# OBSERVATION/SUBMISSION TO PLANNING APPLICATION

Case Reference: 324113

**Re: Observation to the proposed development of open-cycle gas turbine (OCGT) and generator with ancillary equipment.**

Location: Pollnagroagh and Rathmorrissy (Townlands), Athenry, Co. Galway

Purpose		PLANNING			
Title		SITE ACCESS SIGHTLINES			
Original Scale	Design/Drawn	Checked	Authorised		
SHOWN at A1	PS	ND	AJB		
Date	Date	Date	Date		
01.12.25	01.12.25	01.12.25	01.12.25		
Status	Drawing Number	Rev			
A2	PEK3-ATK-ZZ-01-DR-CE-901200	0

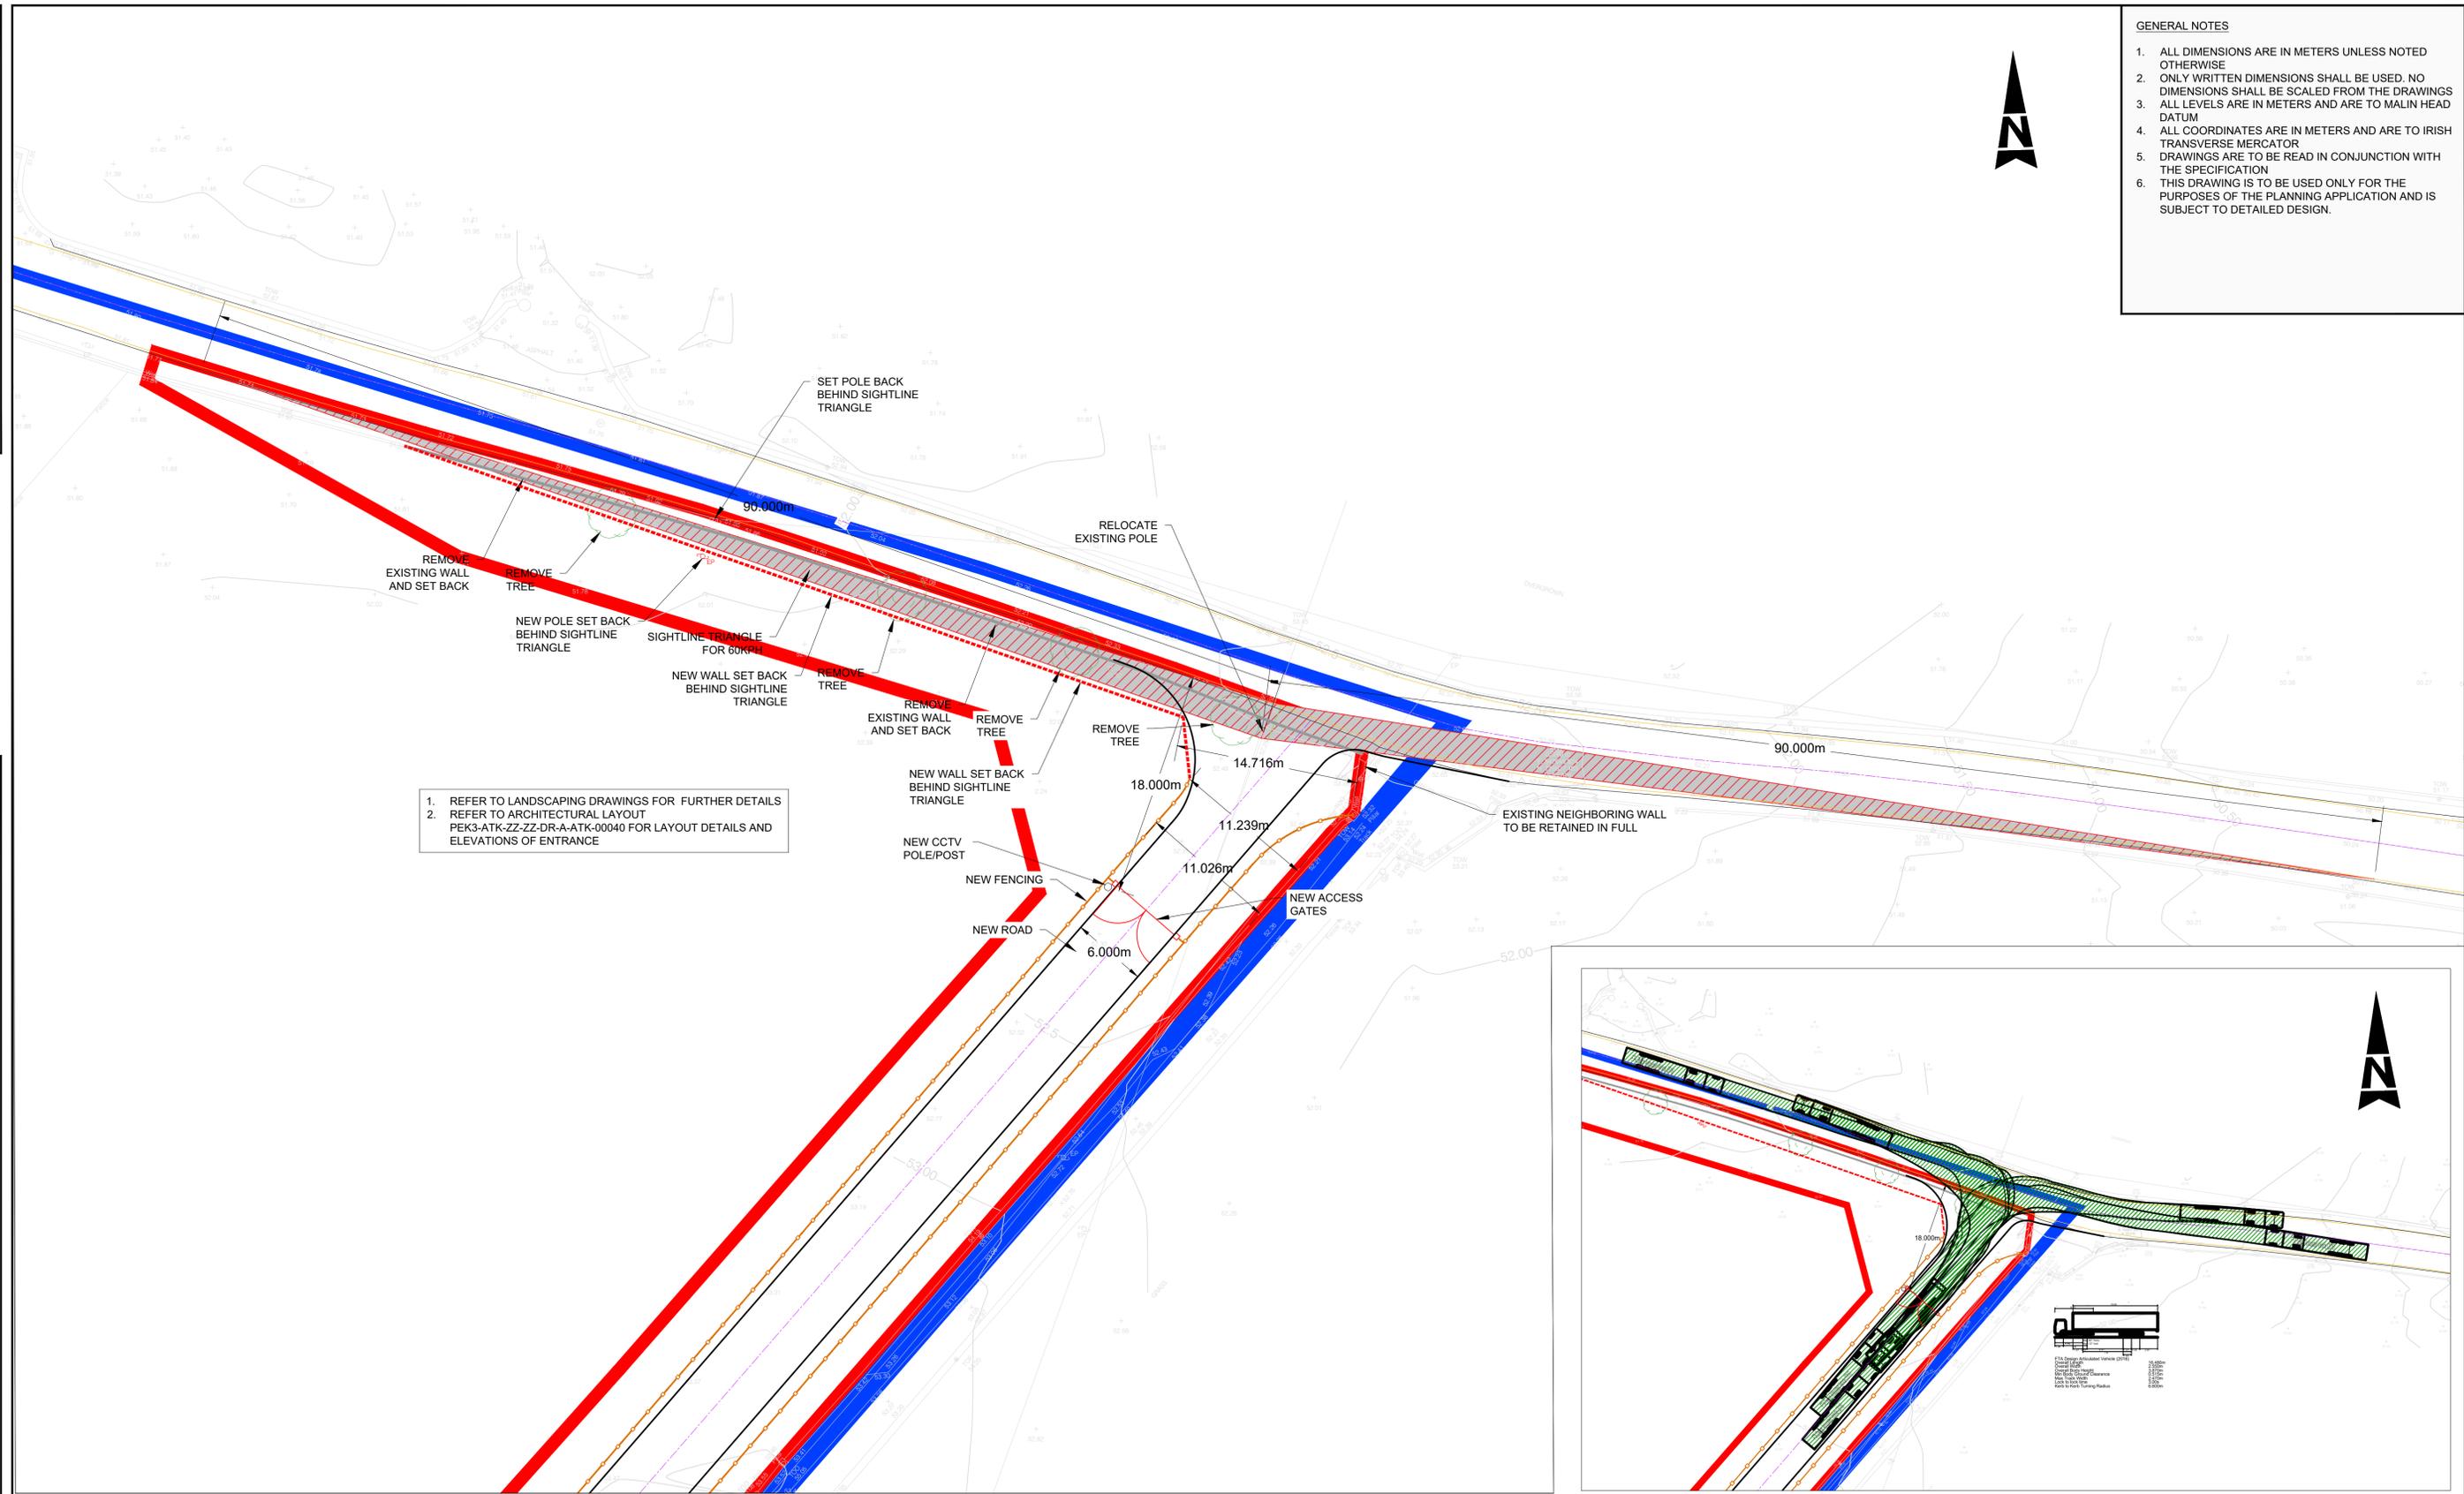
Positioning the site entrance at this location on the L3103 introduces extreme risk to road users. This treacherous section of the road is entirely devoid of a hard shoulder and is physically too narrow for two HGVs to pass one another safely. Furthermore, severely compromised sightlines caused by blind dips and sharp corners make this access point highly perilous. It is imperative that these severe, compounding traffic hazards are urgently mitigated before any development is permitted.
